RE: DRB – Project #1009290 – Southwest Mesa/Snow Vista Substation

In response to EPC Conditions of Approval at the July 12, 2012 hearing, PNM's responses are below.

**Project# 1009290 \***  
12EPC-40030 Site Development Plan for  
Building Permit

DATE: August 31, 2012  
TO: Jack Cloud, DRB Chair  
FROM: Catalina Lehner, Senior Planner *cel*  
RE: Project #1009290, PNM SW/Snow Vista Substation  
Site Development Plan for Building Permit

SHEET 4 OF 7

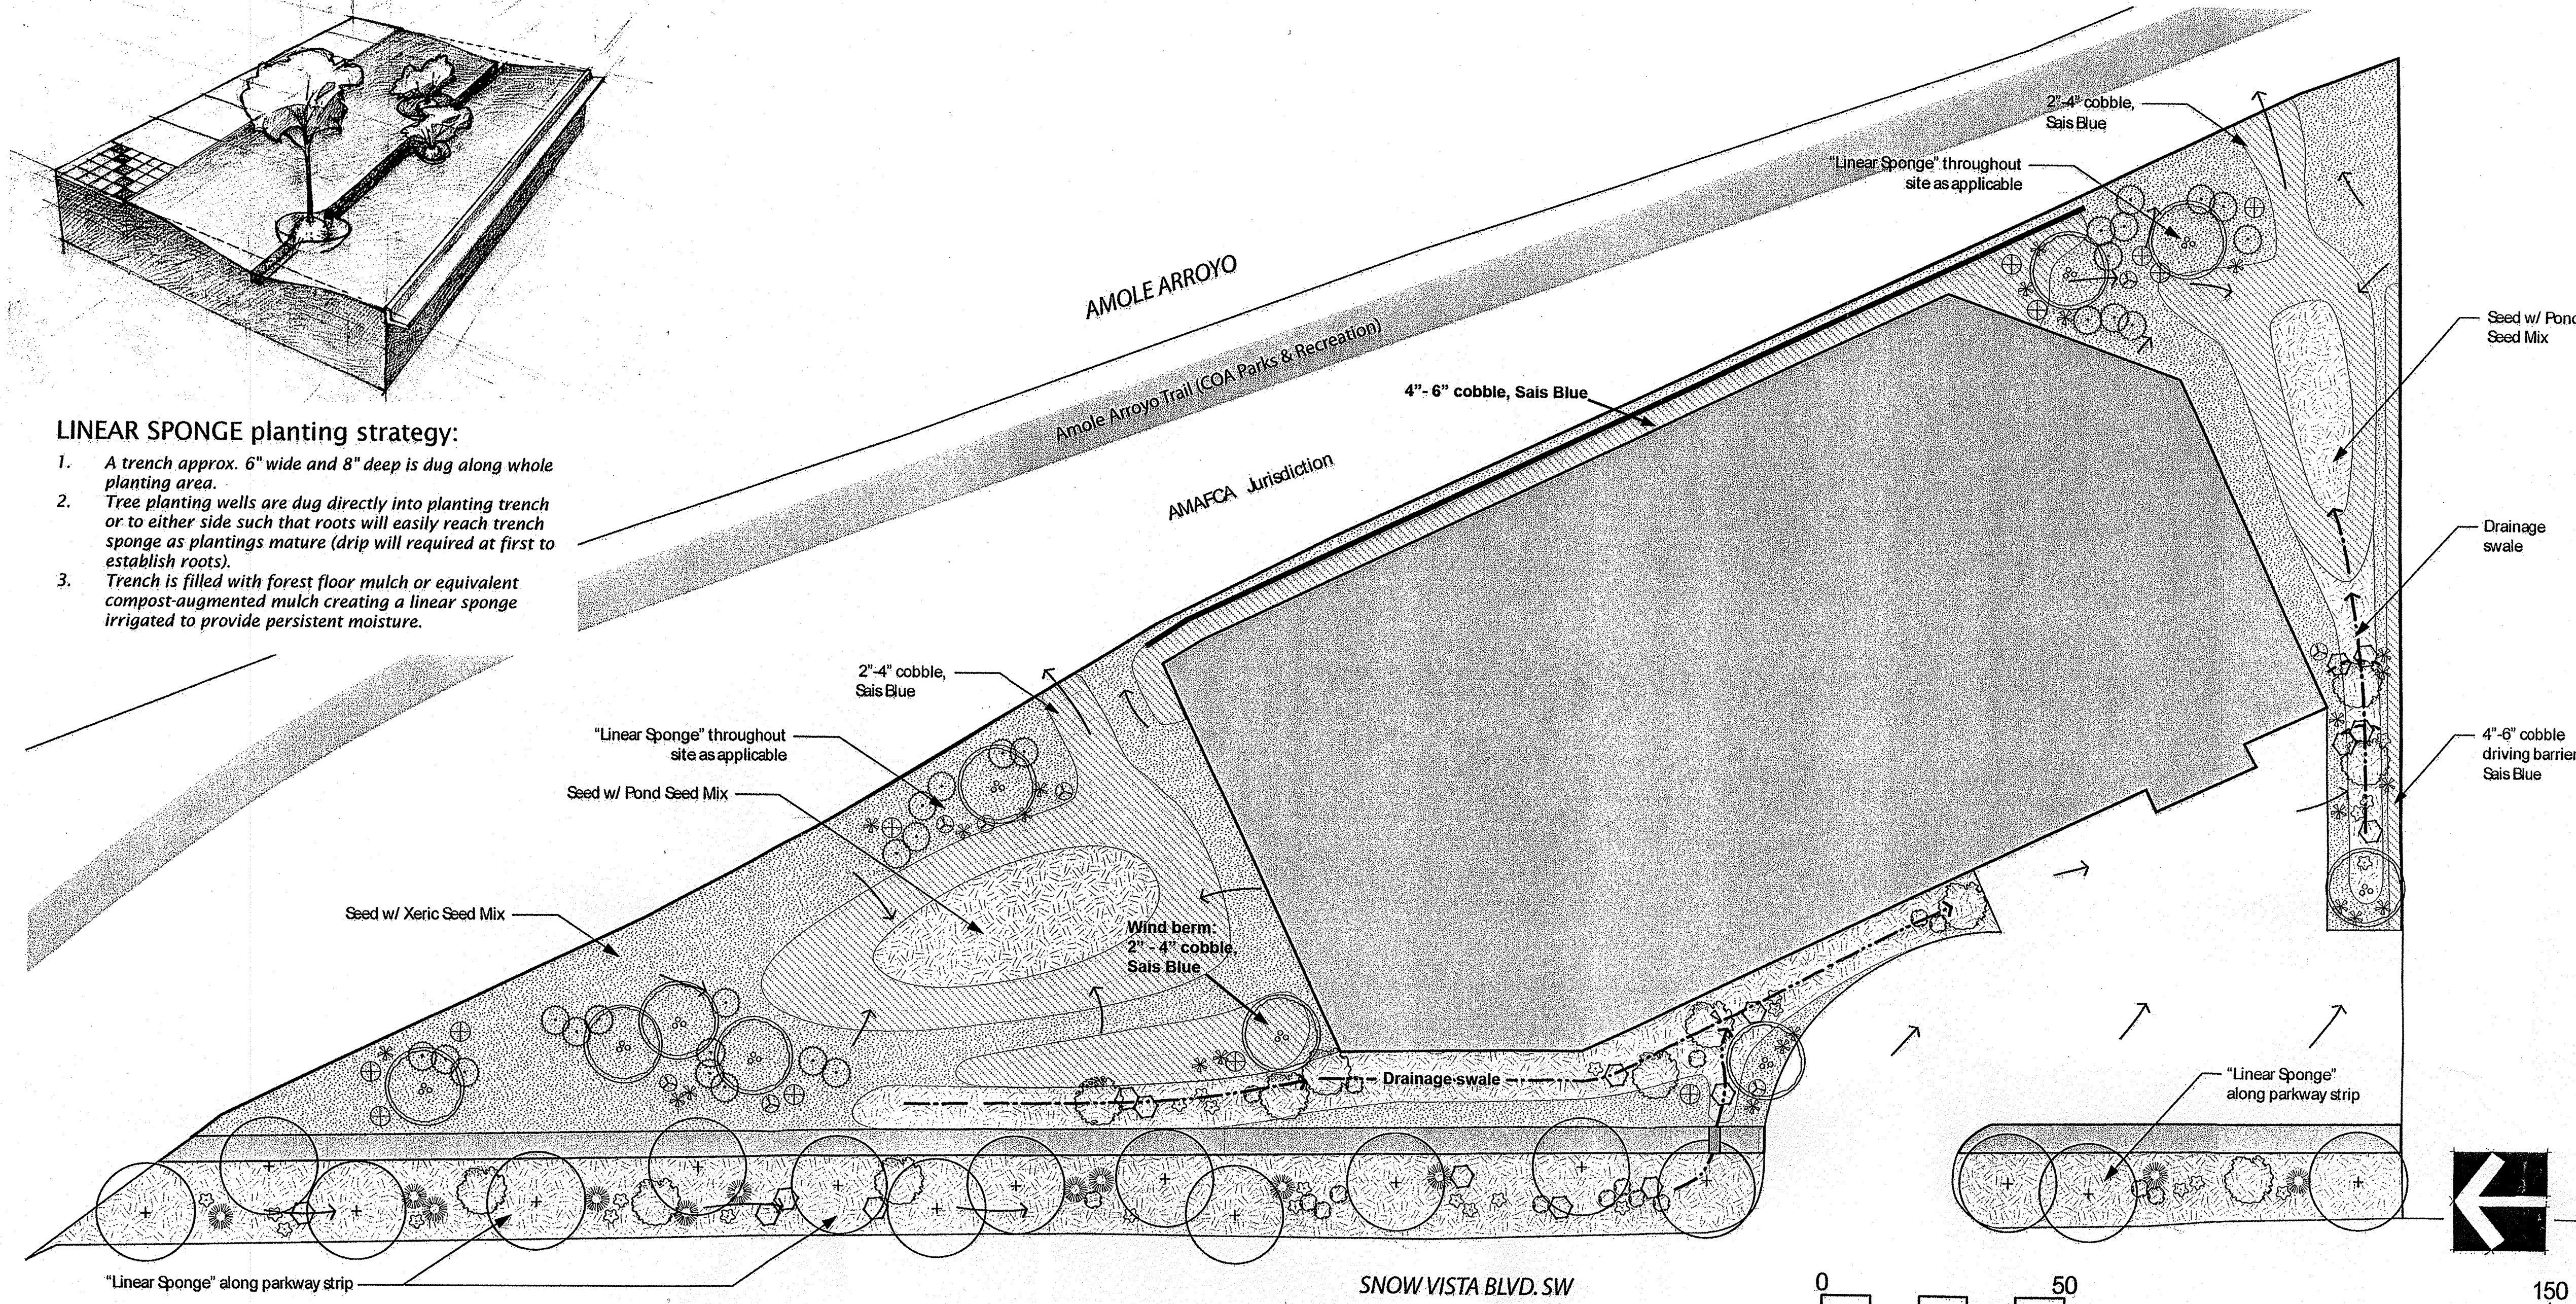
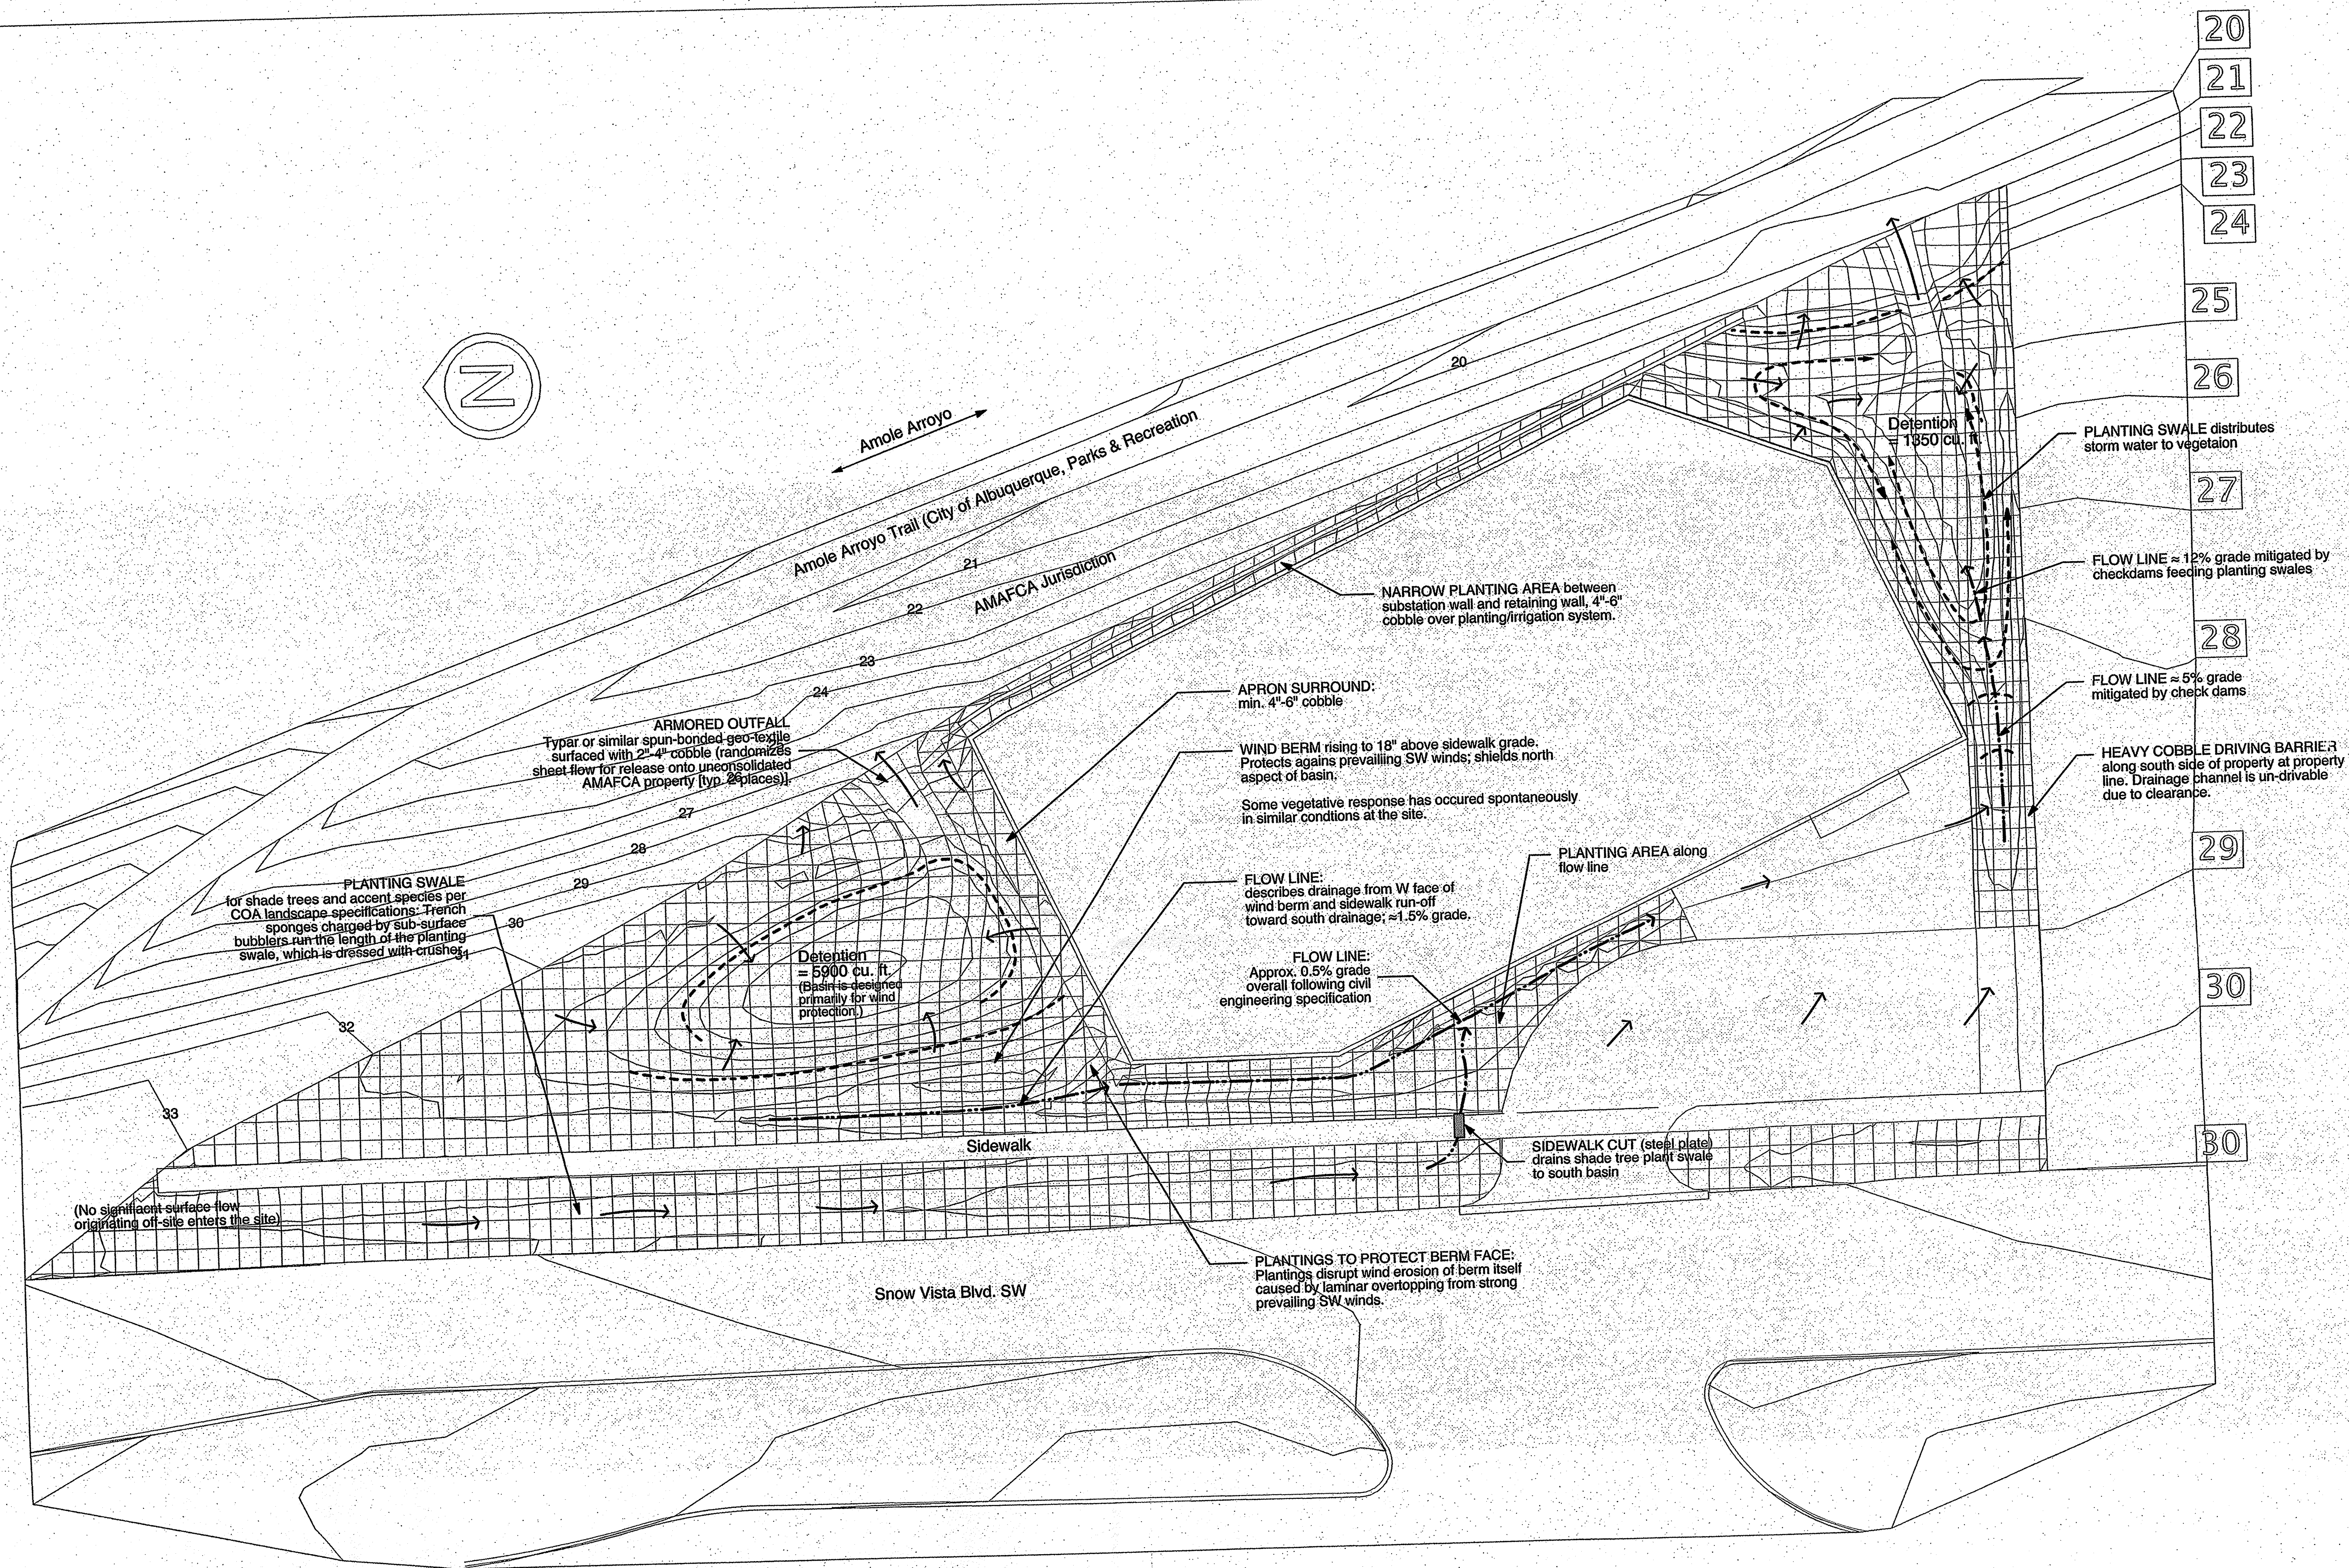
- A. *The landscaping plan shall be reproducible and legible in black and white.*

B. *Indicate the quantity and mature spread/size of the trees and plants.*

C. *Coverage of 75% with living, vegetative material shall be provided (trees do not count).*

D. *Another street tree shall be added near the northern end of the subject site.*

PNM Response: The landscaping plan, Sheet 4, has been revised to be reproducible in black and white.

PNM Response: The landscaping plan, Sheet 4, has been revised to include the quantity and mature spread/size of the trees and plants.

PNM Response: The landscaping plan, Sheet 4, has been revised to include the identified landscape areas and calculations.

PNM Response: An additional street tree has been added near the northern end of the site on Sheet 4.
